**KIRKLEES METROPOLITAN COUNCIL
INVESTMENT & REGENERATION SERVICE**

DELEGATED DECISION TO DETERMINE PLANNING APPLICATIONS

Reference No:	2024/62/90436/E
Site Address:	Papyrus, 45, Northgate, Cleckheaton, BD19 3HS
Description:	Change of use of part of property from retail/office to one dwelling including associated internal and external alterations
Recommending Officer:	Edward Cheseldine

Officer Report

Existing and Proposed West and North Elevations

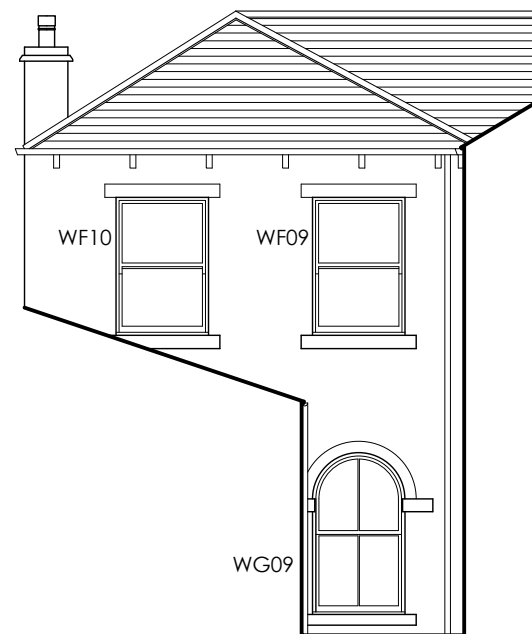
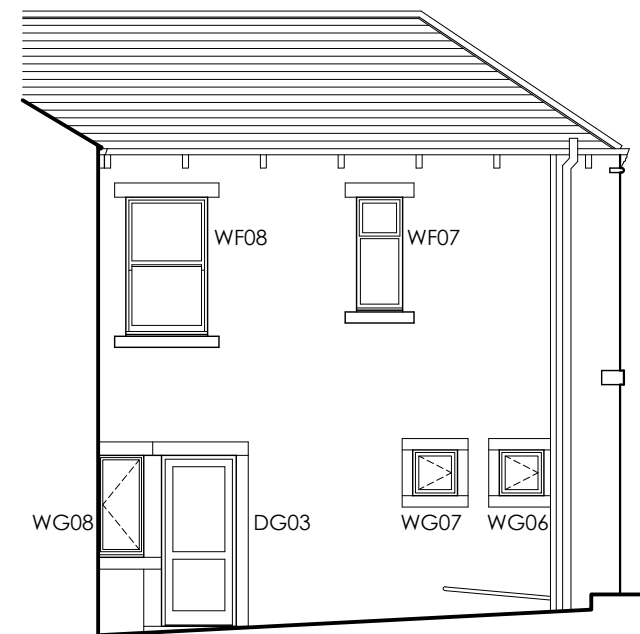
The proposal does not include alterations to the external fabric of the building. The building will remain as it stands. Windows will be replaced with Upvc frames to improve the thermal efficiency of the dwelling. It is a characterful building due to the stone exterior and large window openings. Entrances for each establishment are existing. The plans respect the existing character of

3. Notwithstanding the provisions of section 55(2)(a)(ii) of the Town and Country Planning Act 1990 and the Town and Country Planning (General Permitted Development) (England) Order 2015 (or any order revoking or re-enacting that Act or Order with or without modification) no additional door or window openings other than those expressly authorised by this permission shall be constructed in the building at any time, without written permission from the planning authority.

Proposed First Floor Plan

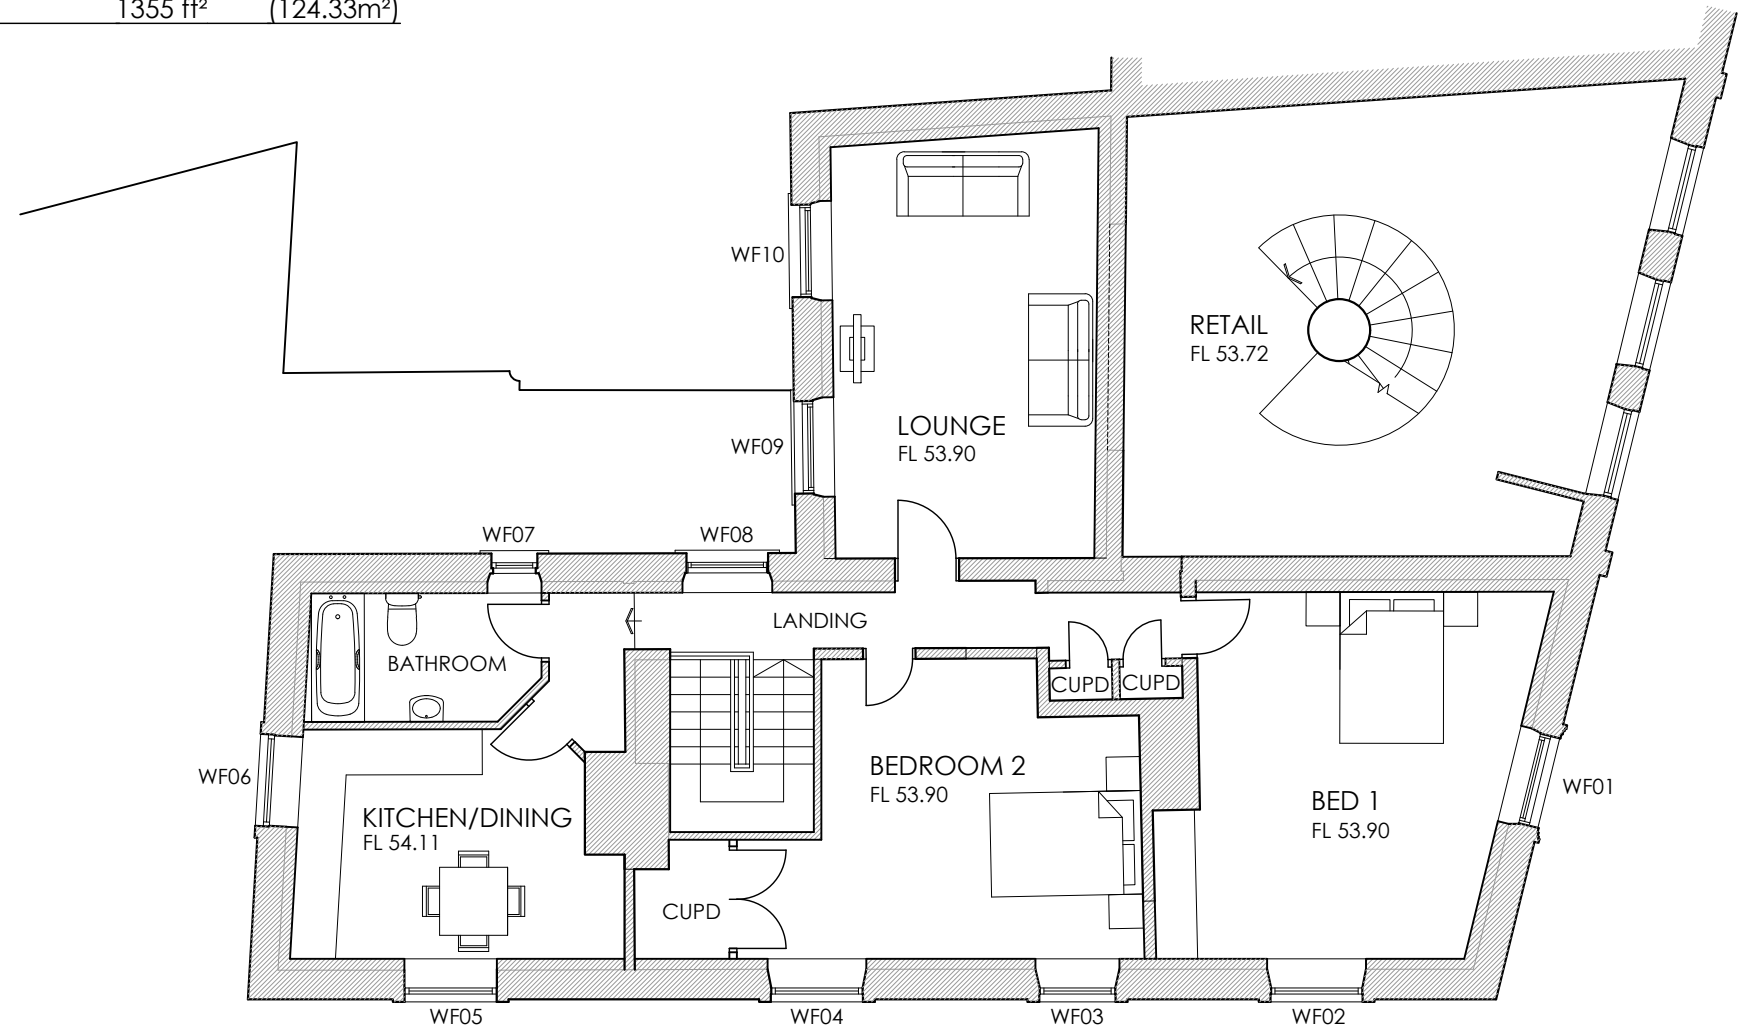
It was considered the internal layout would require altering as bedrooms 2 & 3 had poor outlooks. Internal alterations were received.

The floor plans indicate the dwelling will have two-bedrooms, with living accommodation in the other rooms. It is acknowledged that the internal layout can change, and other rooms could be advertised as bedrooms. Rooms are generally spacious, those indicated as bedrooms conform to the Nationally Described Space Standard, whilst having a satisfactory outlook onto Northgate.

Proposed Ground Floor Plan

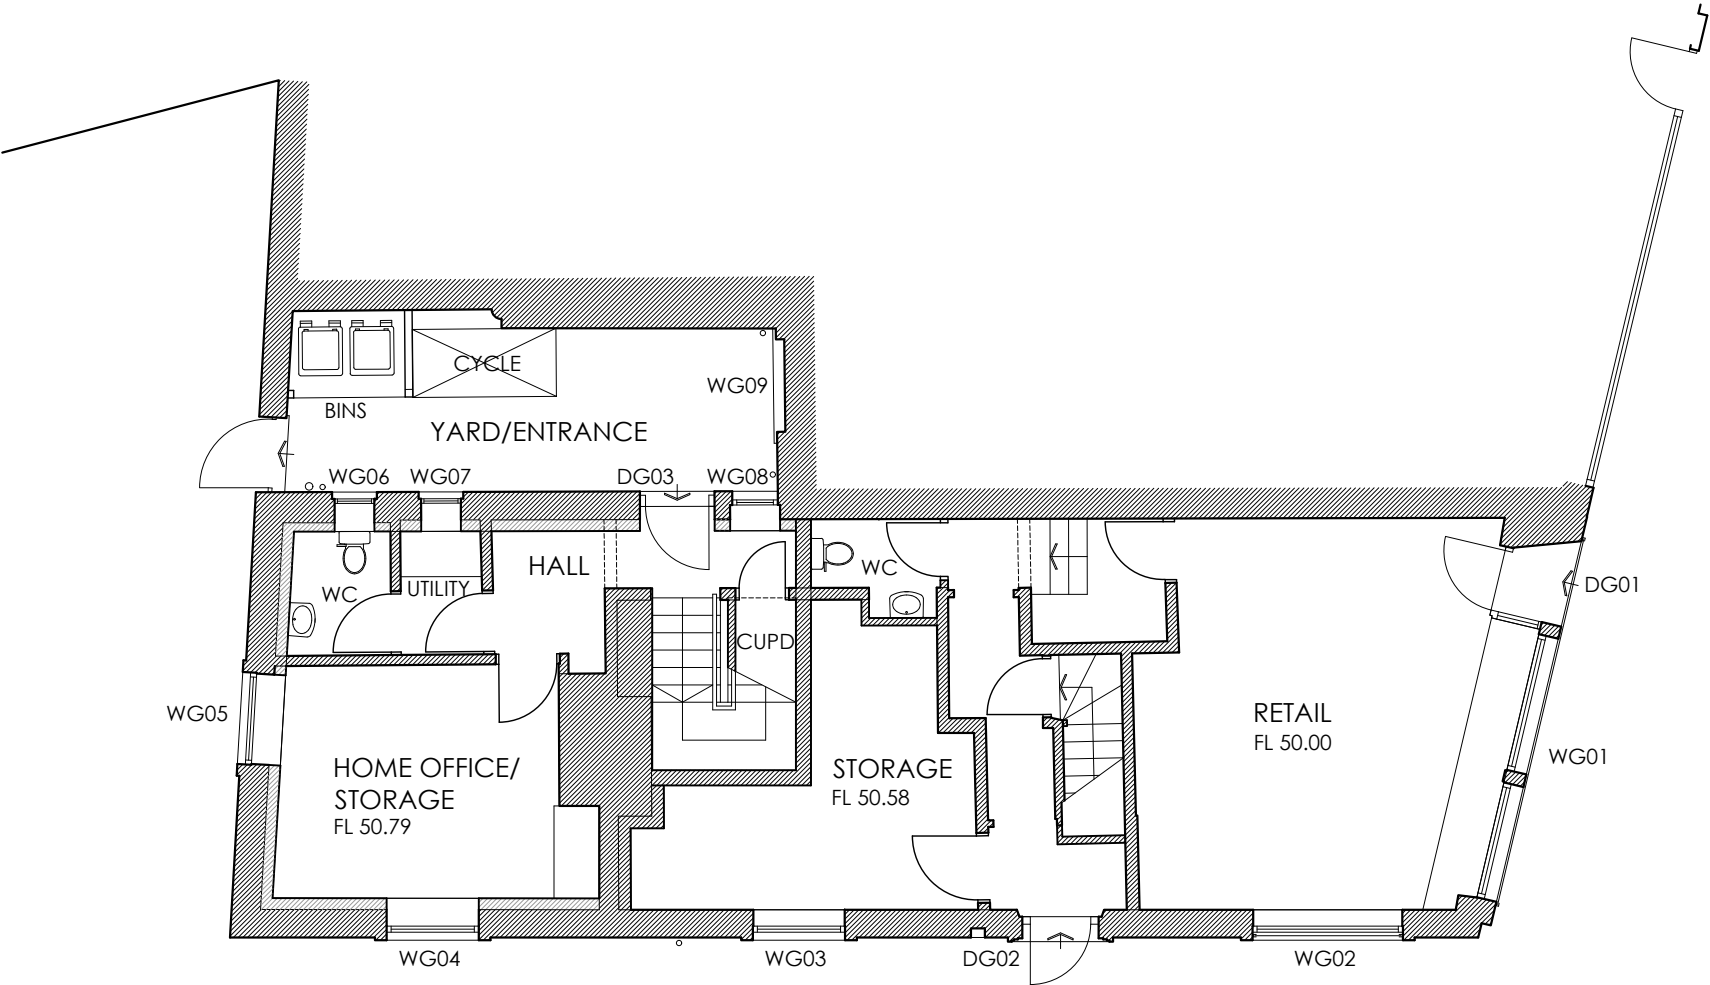
Residential floor space will be introduced on the rear of the ground floor and first-floor. Access to the property will be from the rear external door.

A bin refuse area has been proposed to the rear of the building for the residential dwelling and the retails unit. No information has been submitted in terms of collection of refuse frequency, or type of bin storage. As such it will be conditioned that such information is submitted in writing as a condition.

4. Before development commences details of the management and maintenance of residential and commercial refuse storage areas by a designated private management company shall be submitted to and approved by the Local Planning Authority. The approved details shall be provided before first occupation and shall be so retained thereafter
